**Rezoning Transportation Analysis**  
**Petition Number: Insert Zoning Petition #2021-161**  
*General Location Identifier: 22902119*

**Revision Log:**

Date	Description
08-20-2021	First Review (WB)
09-17-2021	Second Review (WB)
10-18-2021	Second Review (WB)
11-22-2021	Fourth Review (AO)
12-23-2021	Fifth Review (AO)
01-25-2022	Sixth Review (AO)

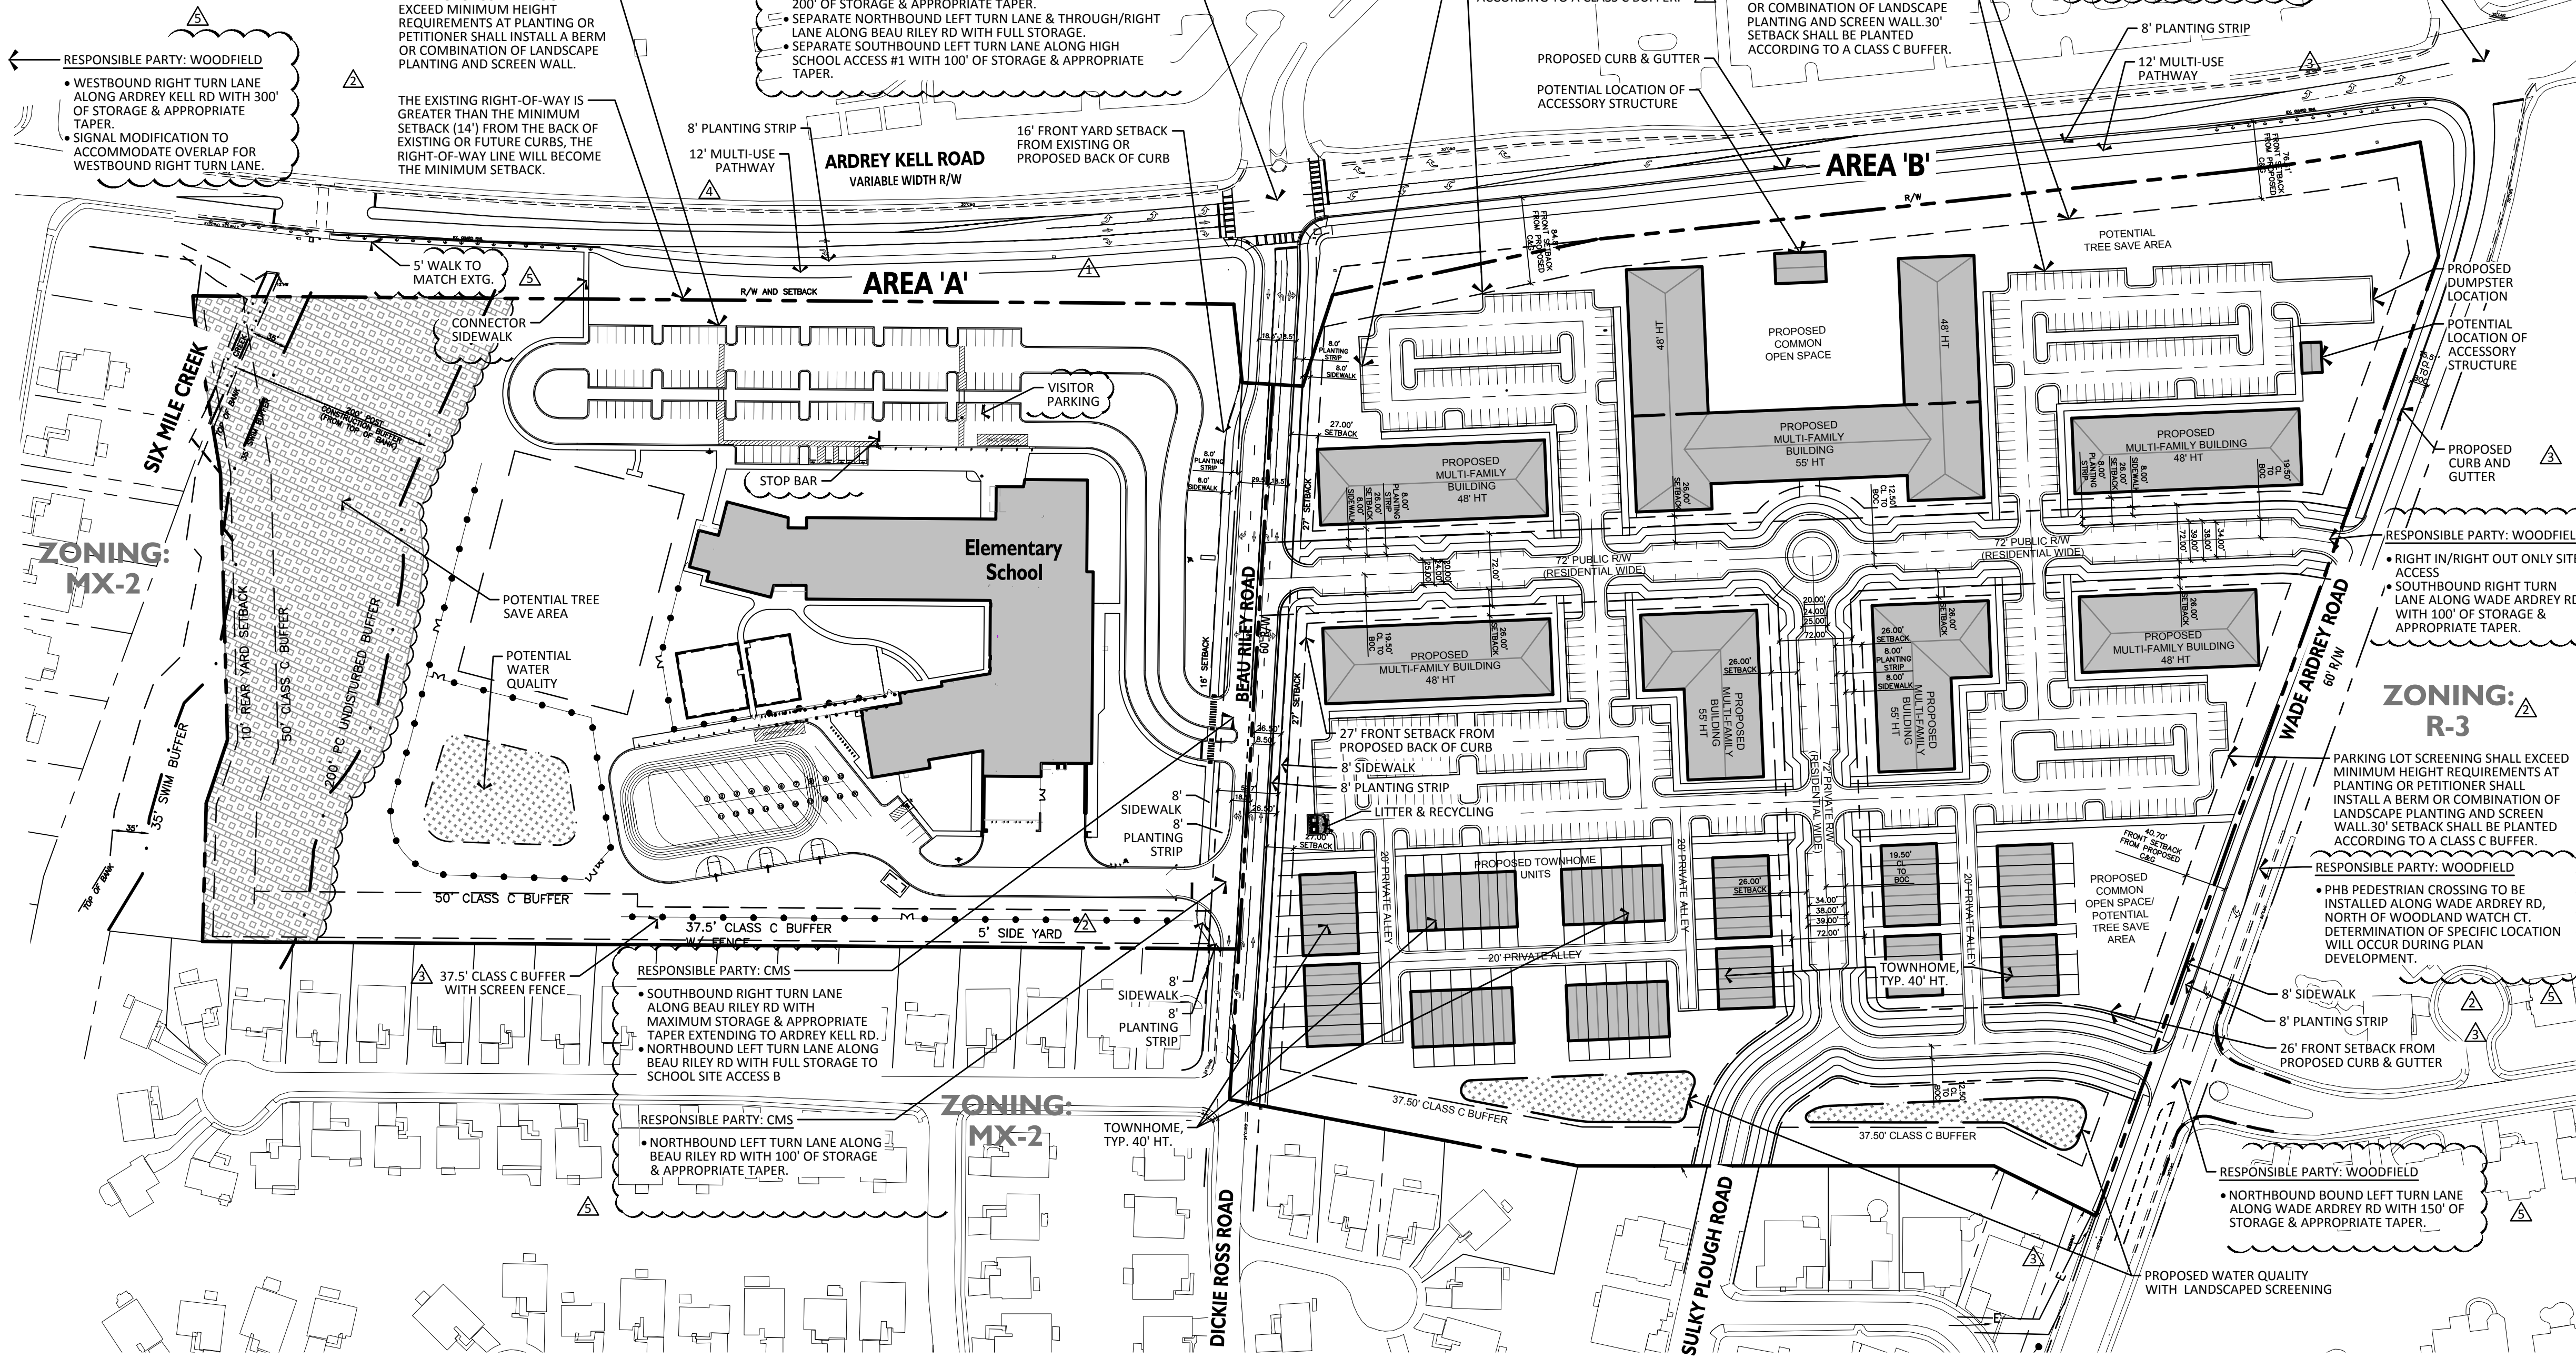
9. **New Comment (New Site Plan: 01-20-2022):** Revise site and conditional note(s) removing 5' sidewalk along Ardrey Kell Rd and show 8' planting strip and 12' multi-use path as shown in previous site plan. Any alternative typical sections will be coordinated during permitted as stated in the conditional notes Section V.4.

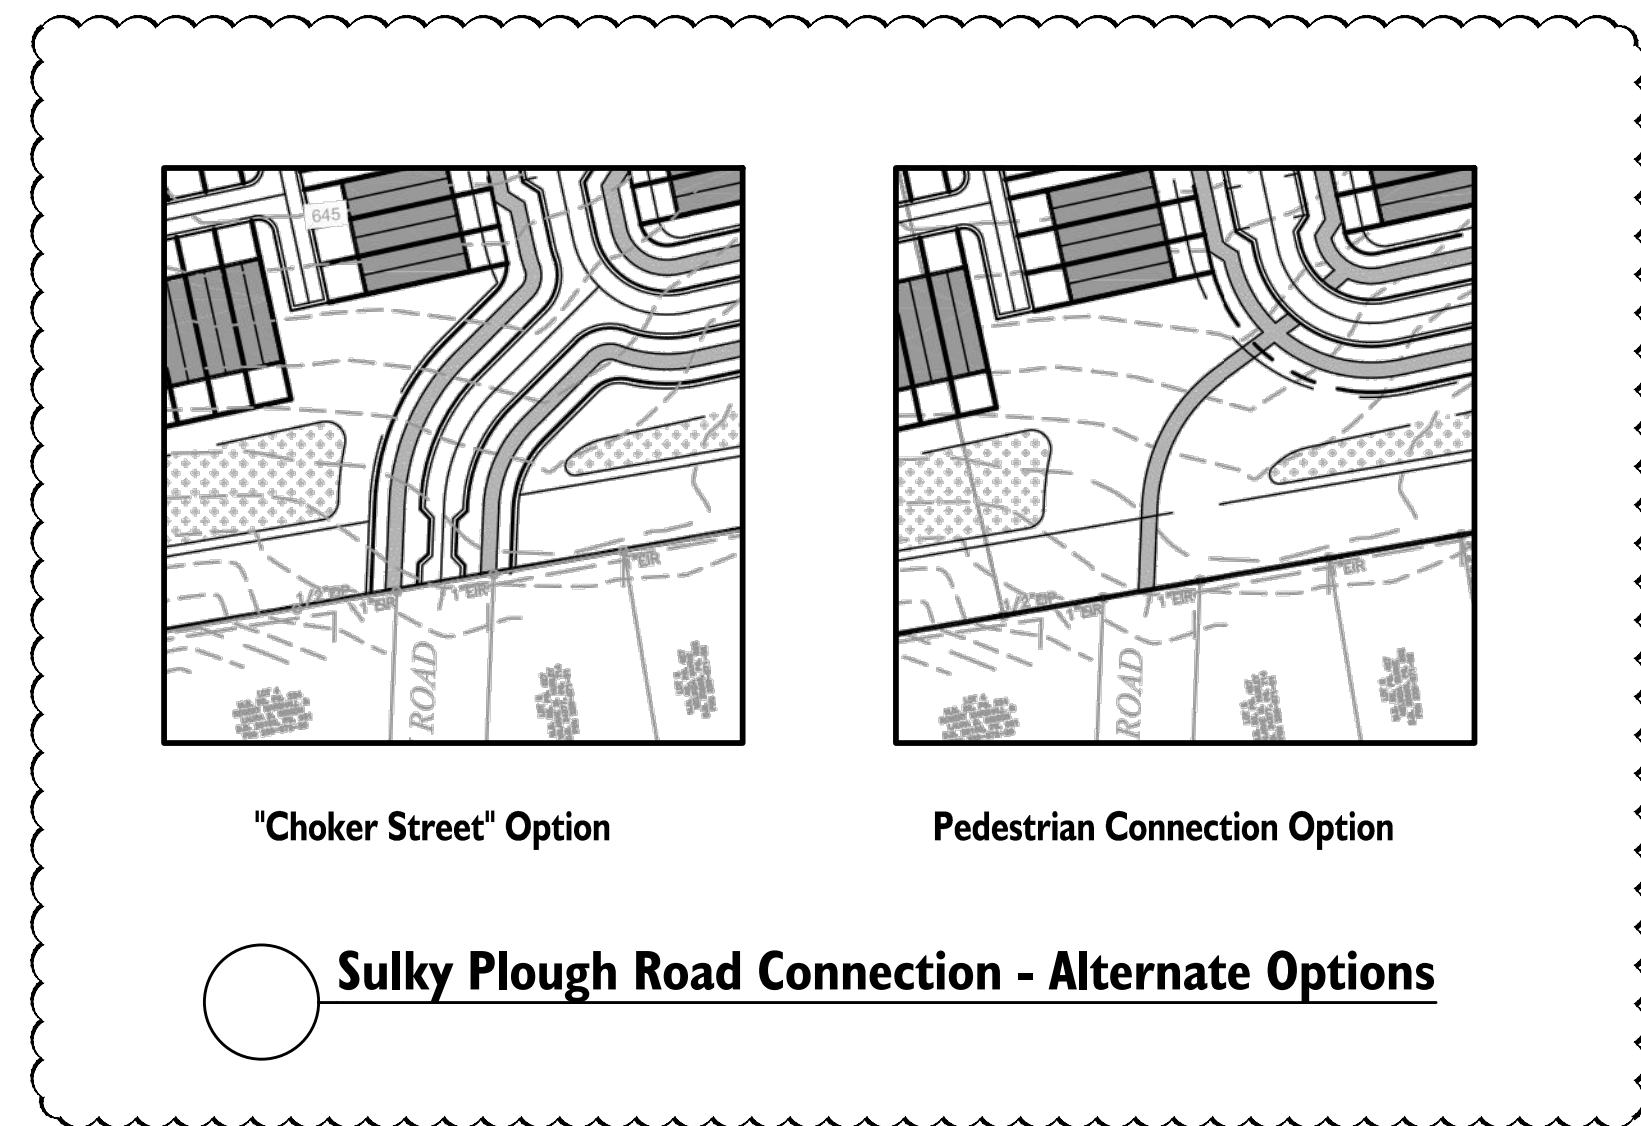
- 5. ~~**Outstanding Comment (site plan dated 11-15-2021):** Revise site plan and conditional note(s) to identify, depict, label, dimension, and itemize all proposed transportation-related infrastructure improvements. The conditional notes should include commitments to fully construct and fund all TIS-recommended and ordinance-required transportation improvements with applicable phasing and funding sources identified.~~
- 6. ~~Add conditional note that all public transportation improvements will be constructed and funded by the residential development before the residential site's first building certificate of occupancy is issued.~~
- 7. **Update to Comment (New Site Plan: 01-20-2022):** Revise site plan inset and conditional notes to remove multi-modal pedestrian connection option.

3. The Rezoning Plan depicts a street connection at Sulky Plough Road. However, as an alternative, the Petitioner(s) may propose a choker street connection to the existing stub at Sulky Plough Road, as generally depicted on the inset within the Rezoning Plan ~~or, as another alternative, a multi-modal pedestrian pathway may be provided in lieu of a vehicular connection,~~ to be coordinated during Land Development.
